Site: Stonestreet Green Solar
Proposal: Application for grant of Development Consent Order ('DCO')
Issue: Written Representation

In accordance with the Planning Inspectorate's Rule 8 letter dated 28/11/24, this letter – constitutes Ashford Borough Council's **Written Representation** ('WR') and follows published guidance. It clarifies and updates the Borough Council's views already set out in its **Relevant Representation** ('RR') (RR-018).

**Drawing Title:**  
Illustrative Layout Plan  
Key Plan

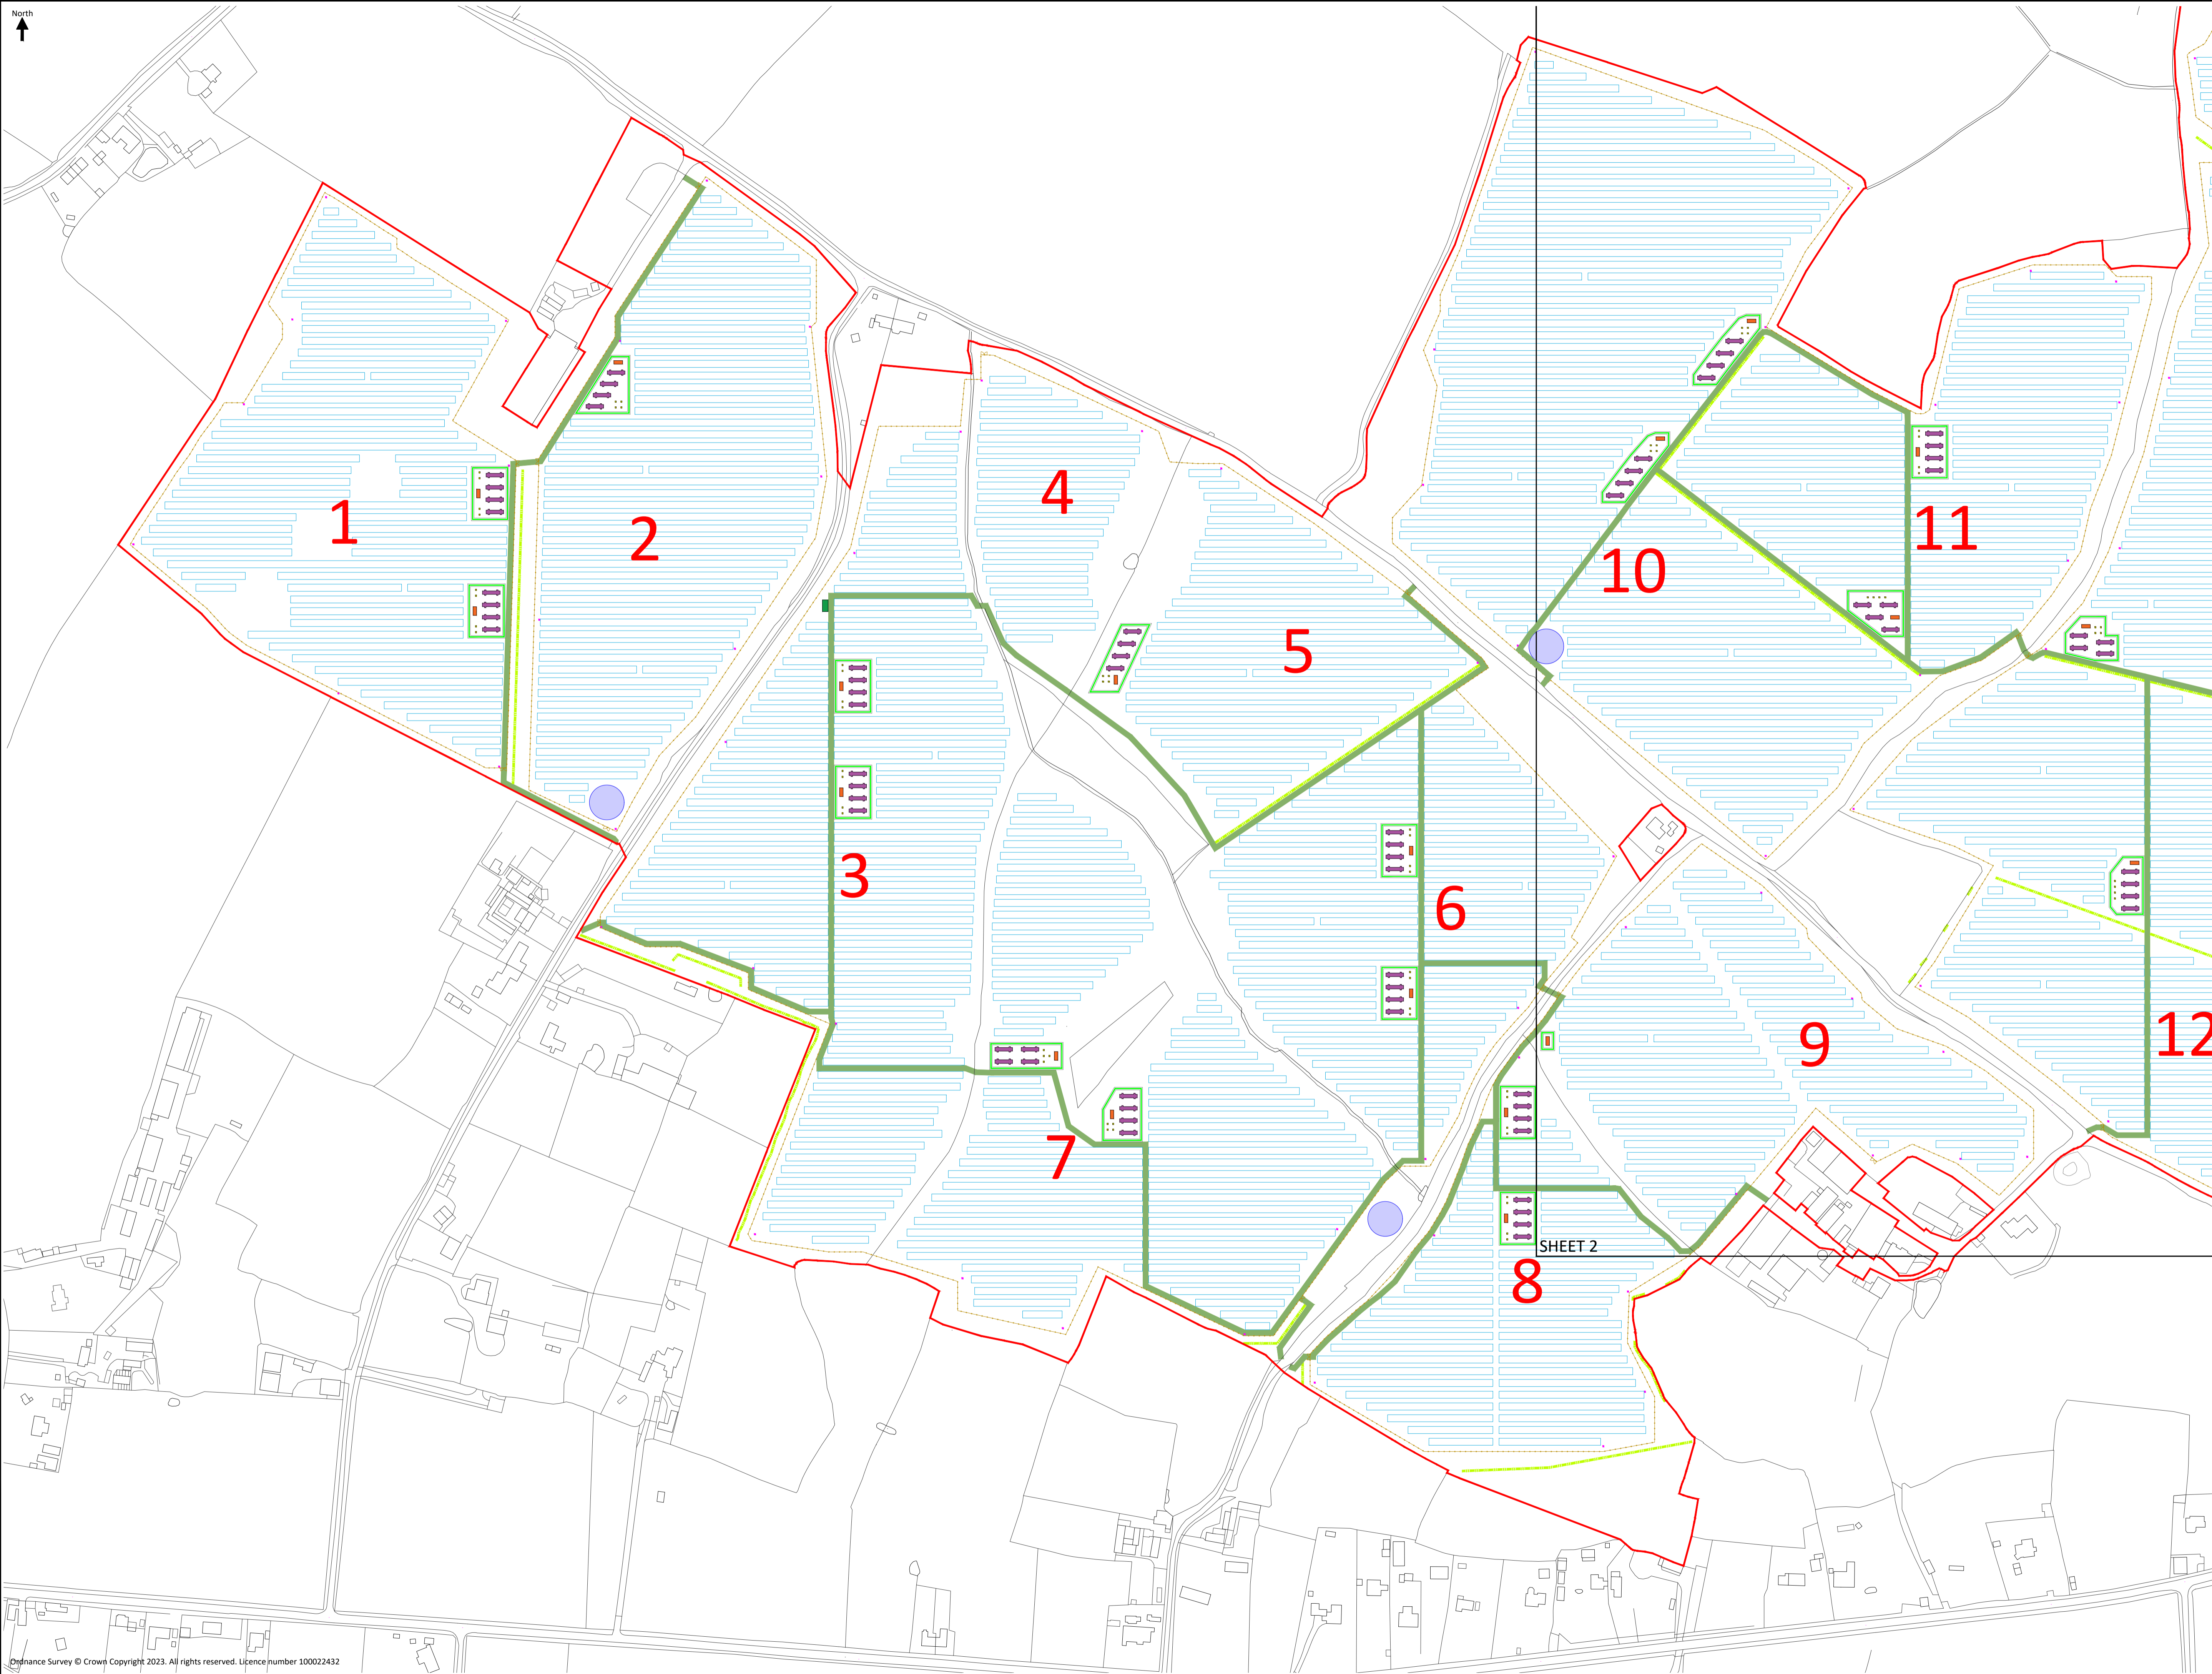
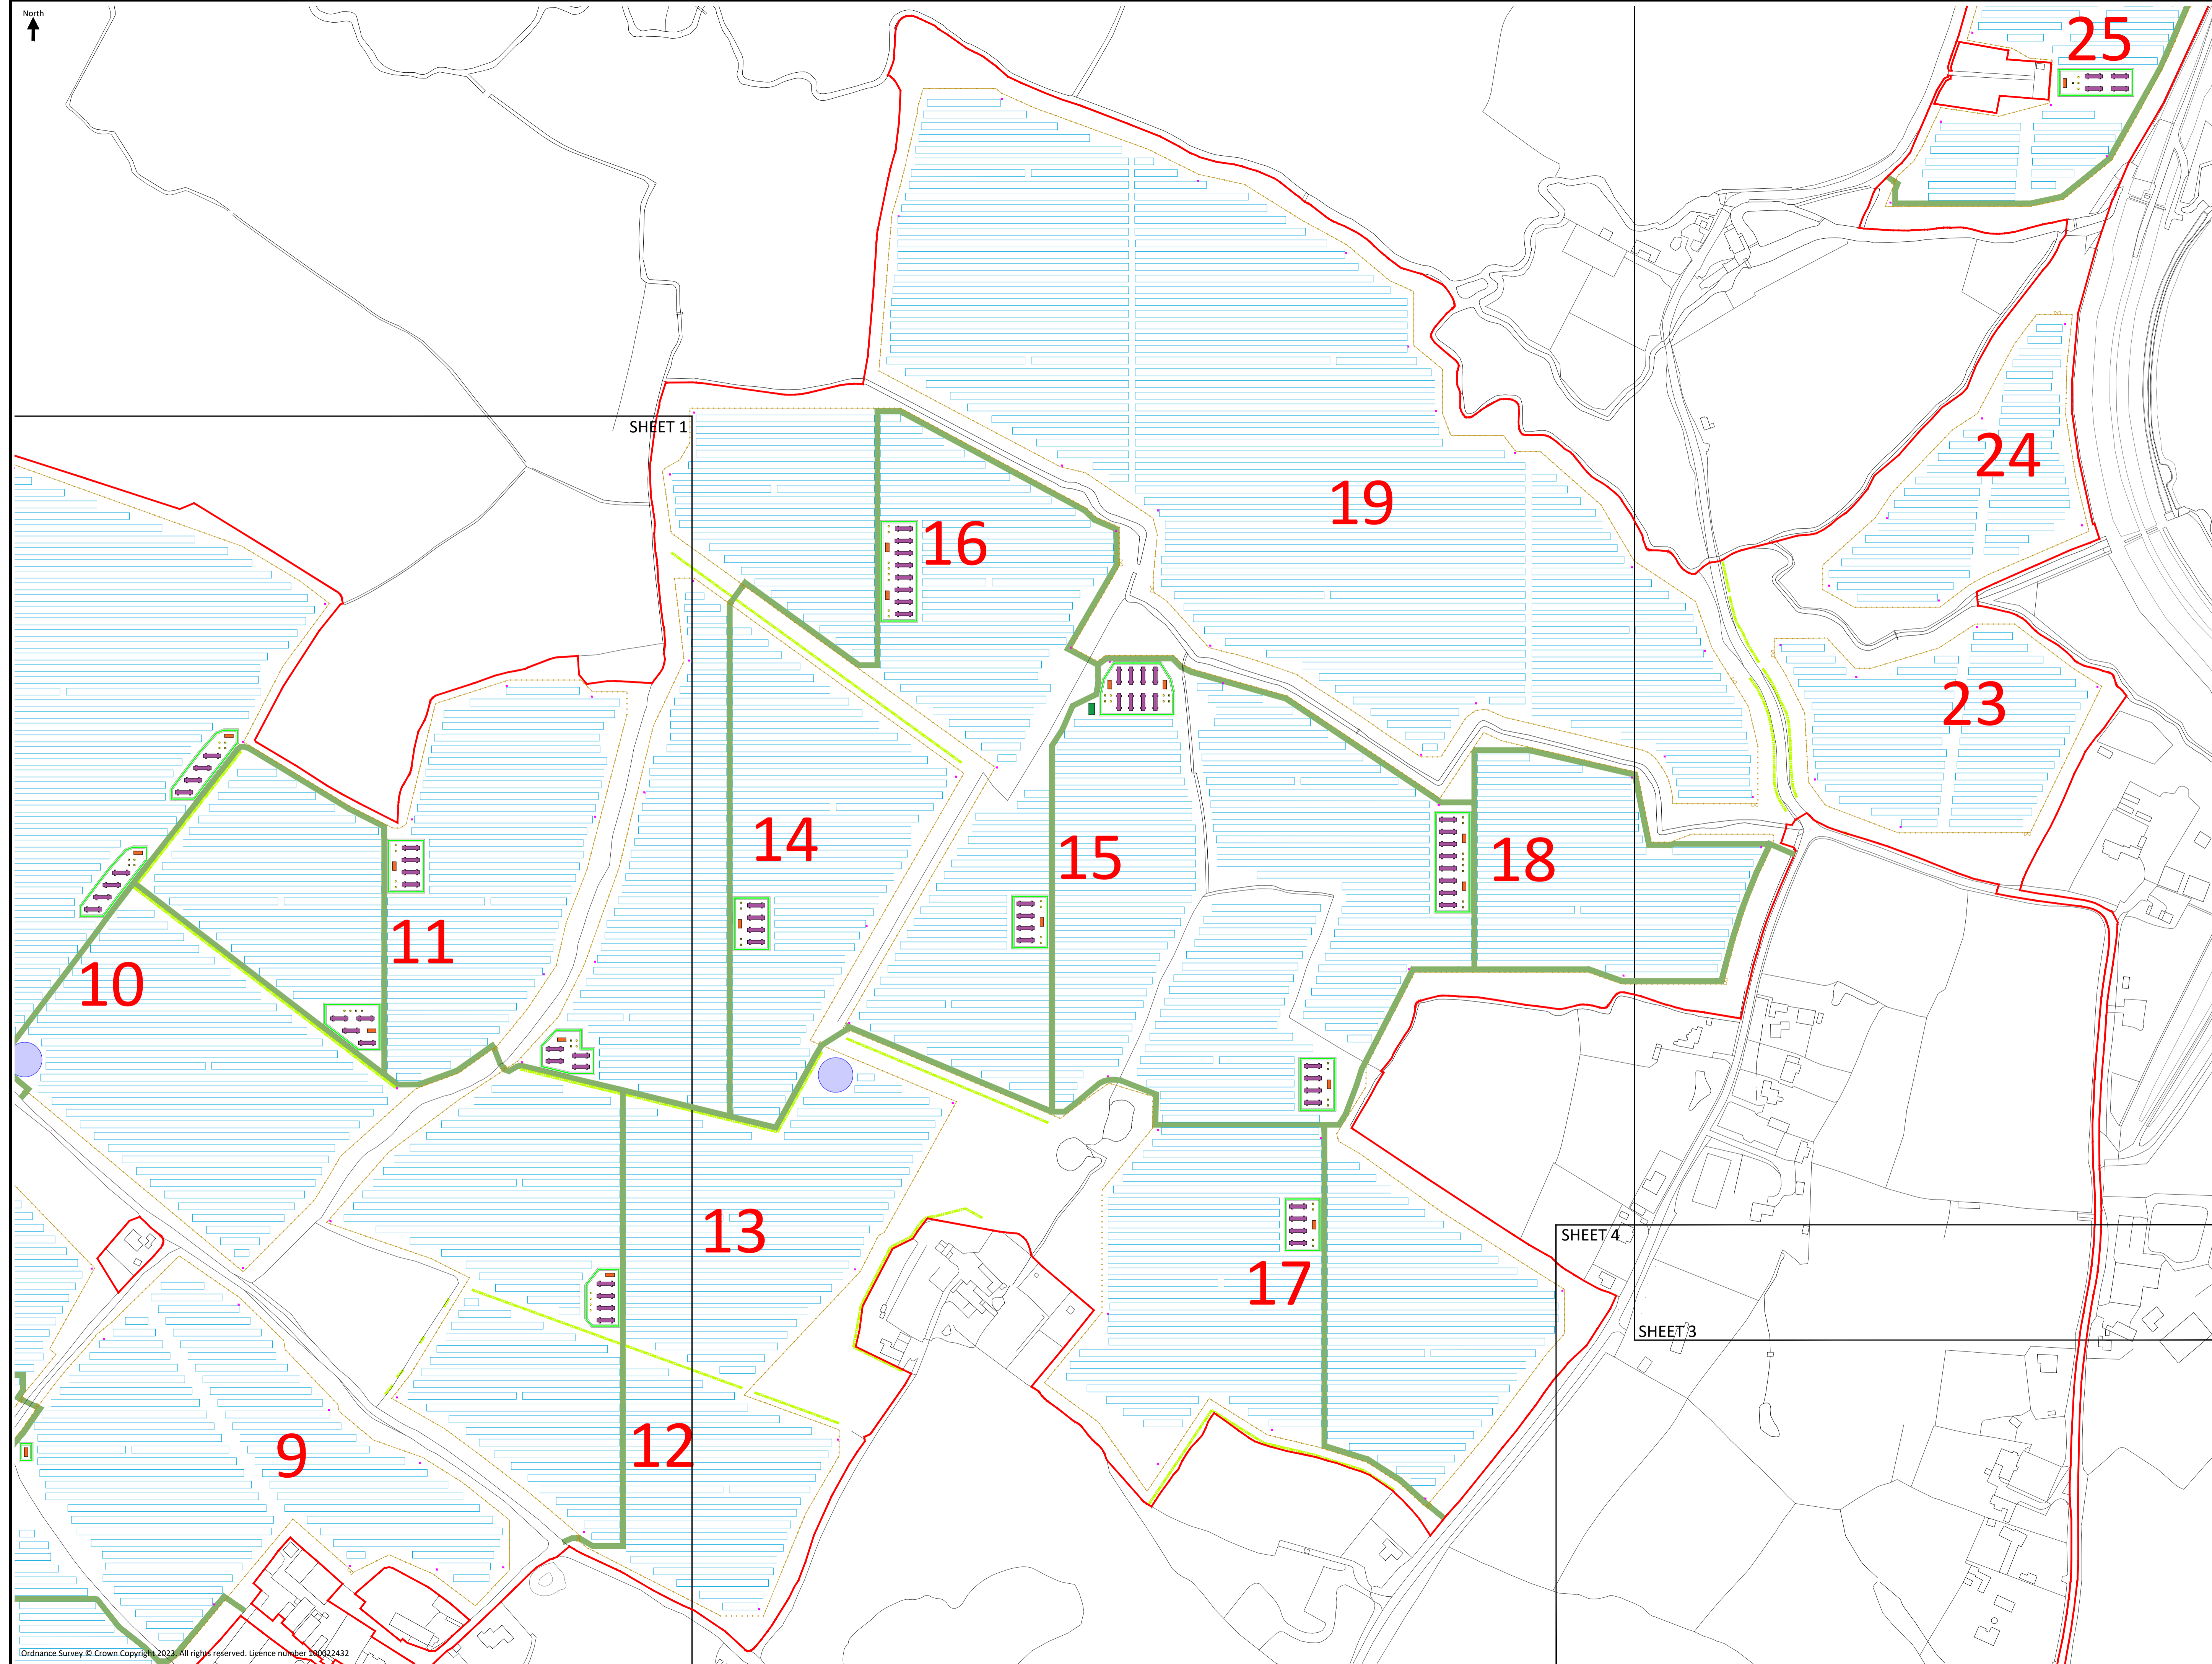
12. As the Council's LIR identifies, the development proposed to occupy Fields 1 to 19 would form a substantial largely unbroken continuous area of solar panels arrays and associated electrical infrastructure that will include Battery Energy Storage Systems (BESS) and this will have a significant adverse residual landscape and visual impact on the Aldington Ridge Local Character Area.

13. The Council requested removal of solar development from Fields 10 and 12 because these effects would be located on the crest of the Aldington Ridge that is highly visible from the PRow network and from the Station Road approach southwards towards the village. The Aldington and Bonnington Neighbourhood Plan ('A&BNP') Policy AB4 viewpoint 1 establishes the importance of this view up to Bank Road.

17. Given the significant adverse residual landscape and visual effects, the Council also suggested to the Applicant the importance of breaking up the expanse and intensity of the Field 1 to 19 area.

24. The Council considers that enhanced softening, primarily in the form of increased physical separation, should be provided to the south and south-west of Field 20 to moderate the impacts of solar infrastructure on users of PRow AE474 that connects Goldwell Lane to Church Lane. This area for proposed solar generation dips away to the north but the southern boundary is especially important because of its proximity to PRow AE474. A&BNP Policy AB4 viewpoint 2 identifies the importance of the views when using the route in both directions. The Council remains concerned that the scheme will necessarily impact on the experiential qualities enjoyed by PRow users because its qualities include;-

26. As set out in the Council's LIR, the recommendation by Historic England ('HE') to reduce the harm to the setting of Stonelees, a Grade II* listed building, by retracting the proposed development at the southern ends of Fields 3 and 7 is one that the Council supports as part of 'softening'.
